Application No: FP/237/20/HH
Site Address: 30 Davenport Road Felpham PO22 7JS
Description of works: Raised deck and increased height to perimeter fence in rear garden.

Thank you for your internet representation made on 9th January 2021 which has been recorded as an objection with the comments as follows:

Proposed Drawing - Rear Garden Plan & Fence Elevations

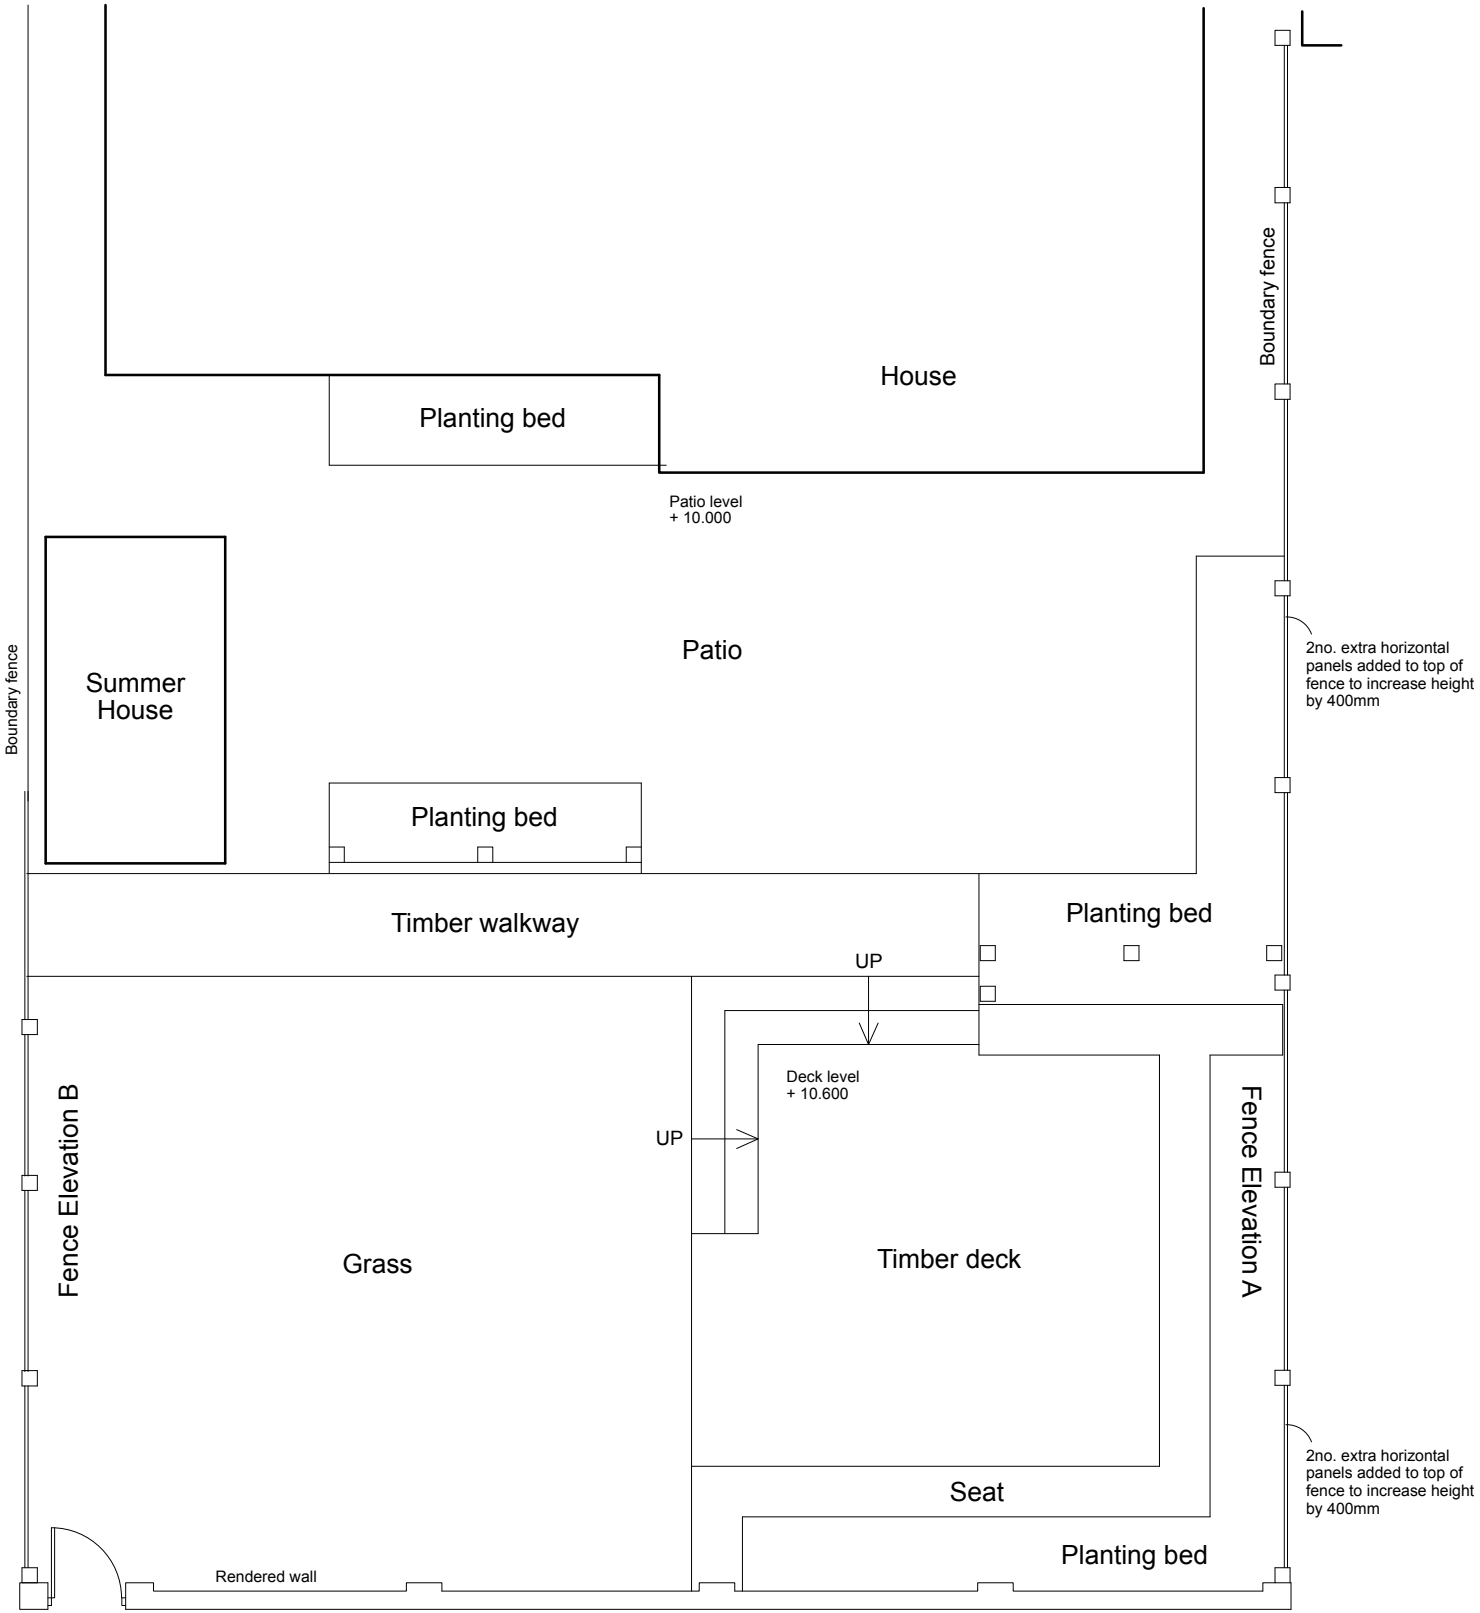
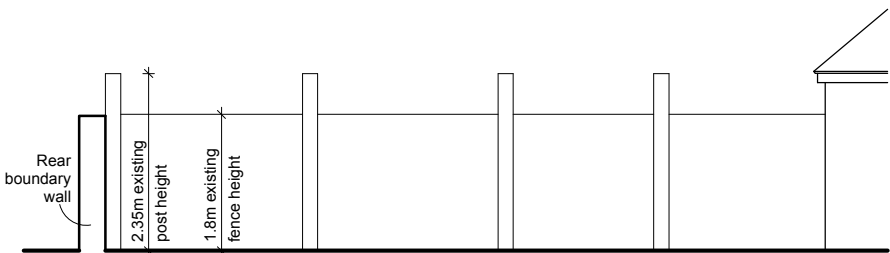
We are against the raised decking/platform built in spring 2020 without planning permission to a height of approx 60 cms. (Double the permitted height without planning permission) alongside our fence line. We did make our concerns known to the owners of no 30 in a polite message at the beginning of the construction process, only to receive the reply on 16th May that "they had asked their garden designer to apply for planning permission"

Although we appreciate we are already overlooked by a small bedroom balcony on their house, this is entirely different to being overlooked by gatherings of multiple people on the platform, as has been the case over the summer months.

We of course would welcome the increase in height of the fence by 40 cms to counteract the situation somewhat, so would be in favour of the higher fence if planning permission is granted for the raised platform.
